**DEVIATION REQUEST  
AND DECISION FORM IN  
ASSOCIATION WITH A  
REQUEST FOR A PUD  
MODIFICATION FROM  
THE ECM**

A deviation from the standards of or in Section **ECM 2.3.8** of the Engineering Criteria Manual (ECM) is

Roadway terminations

Fire Truck Turning Exhibit

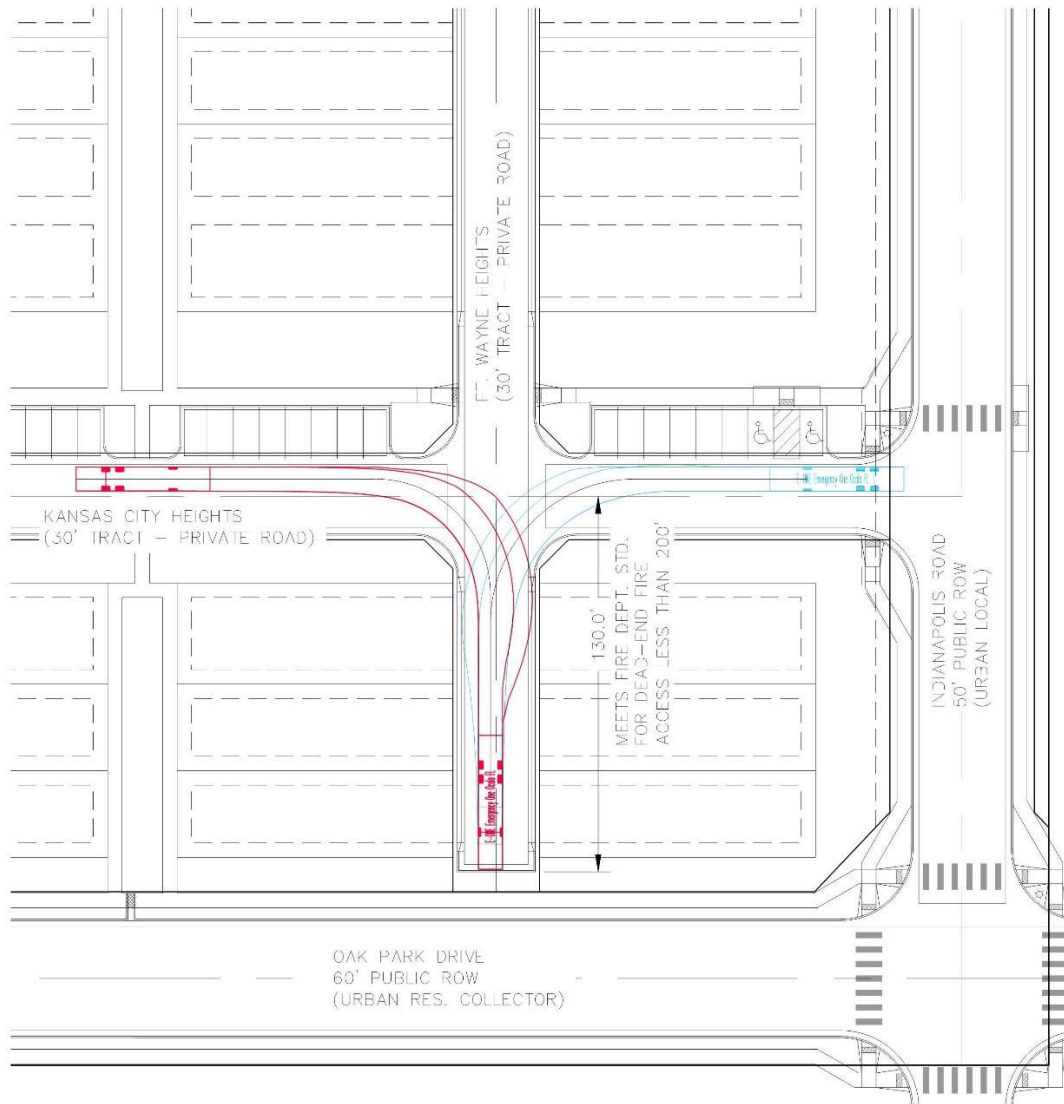
Include an exhibit with the proposed termination details and map showing where the proposed terminations would be located.

**Provide verification that fire district has given approval for roadway terminations.**
